October 29, 2025
Development Facilitative Team (DFT)
600 2nd St NW, Albuquerque, NM 87102

RE: Project: PR-2022-007565; SP2025-00075- SITE PLAN DFT Comment responses

To whom it may concern,
I am in receipt of comments provided on 10/22/2025 and have provided the following revisions, and responses to those comments:

Sheet Number:
A201

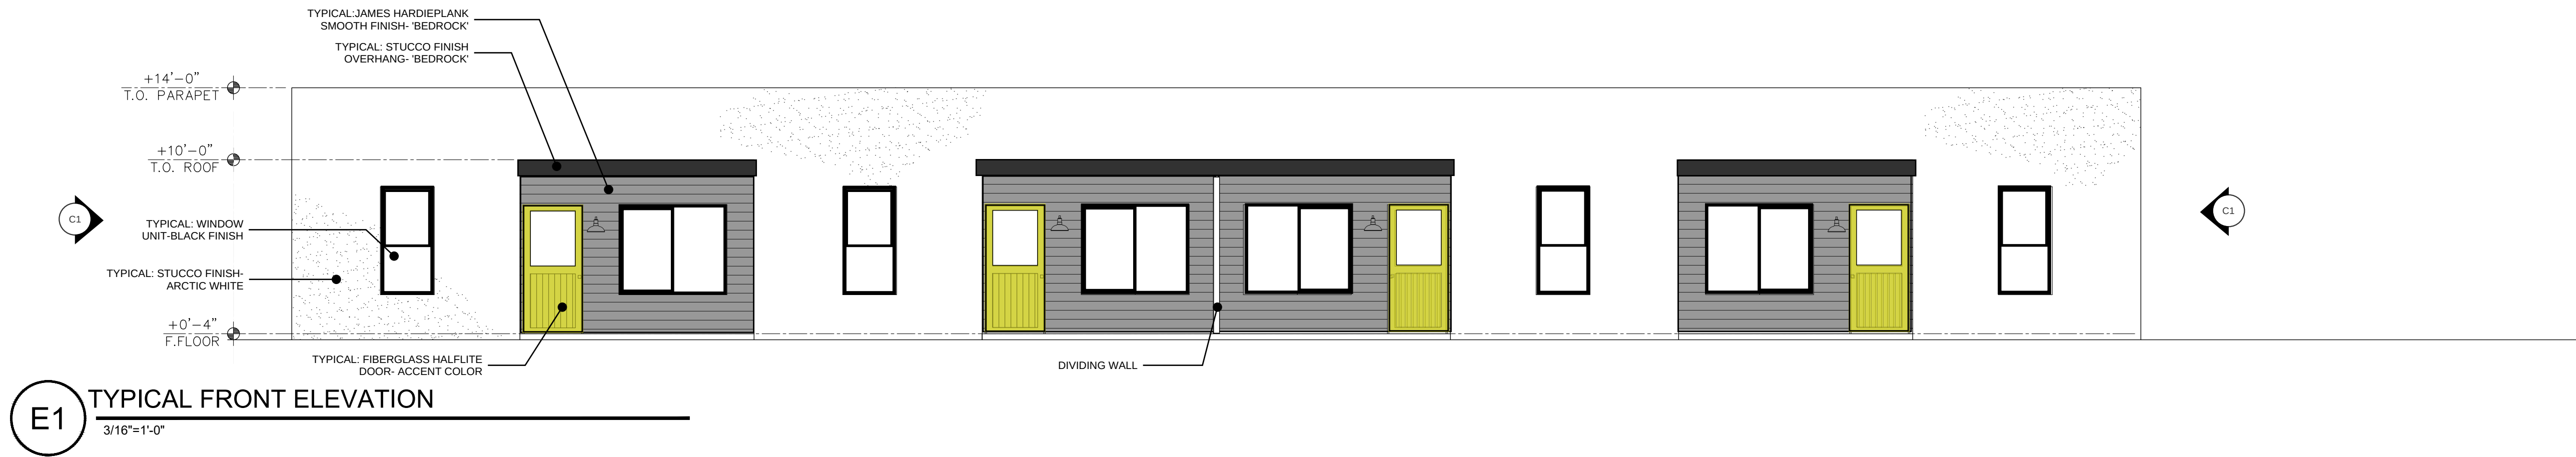
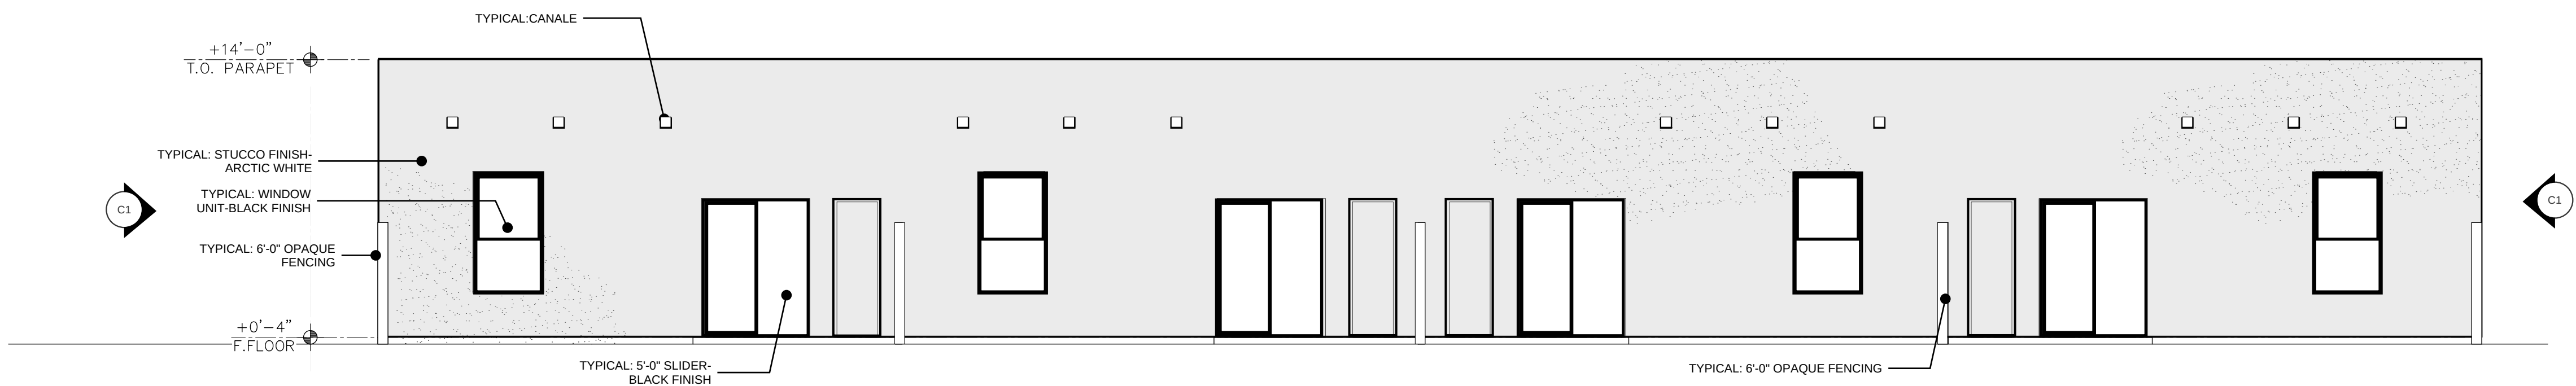
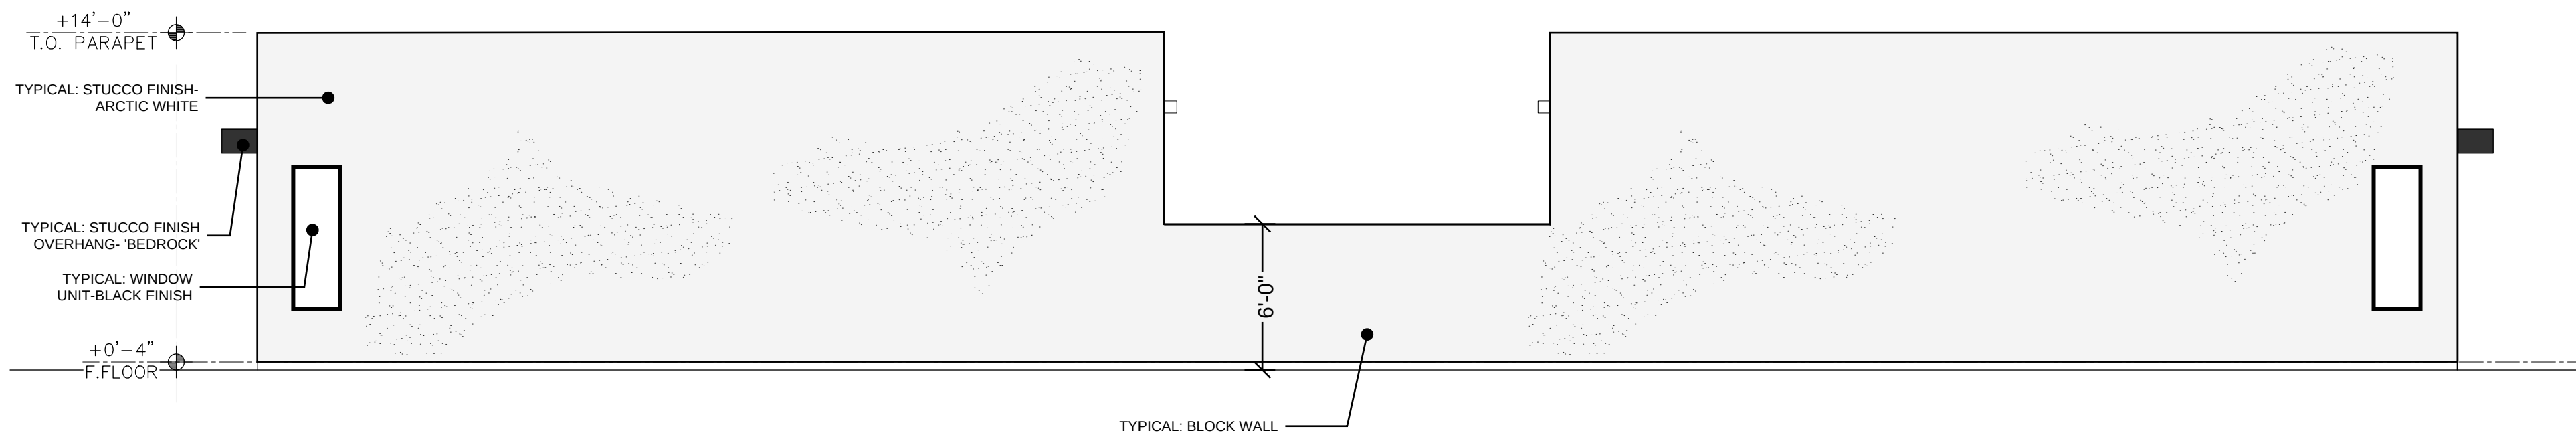
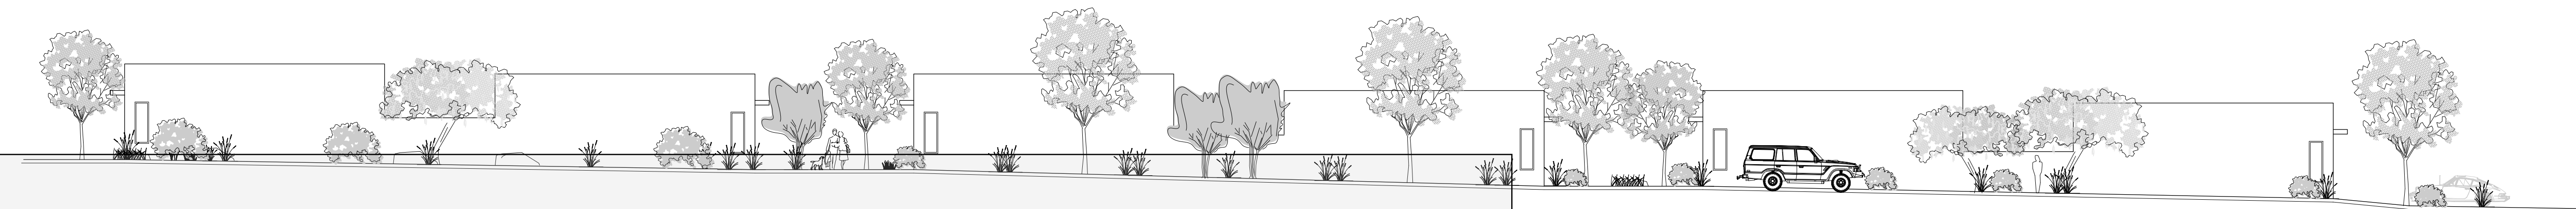
1. Add a detail to the elevations sheet showing the proposed 6' opaque fence shown as keyed note #6 on the site plan.

Response: Detail showing proposed material and construction of the opaque fence has been added to sheet A201.
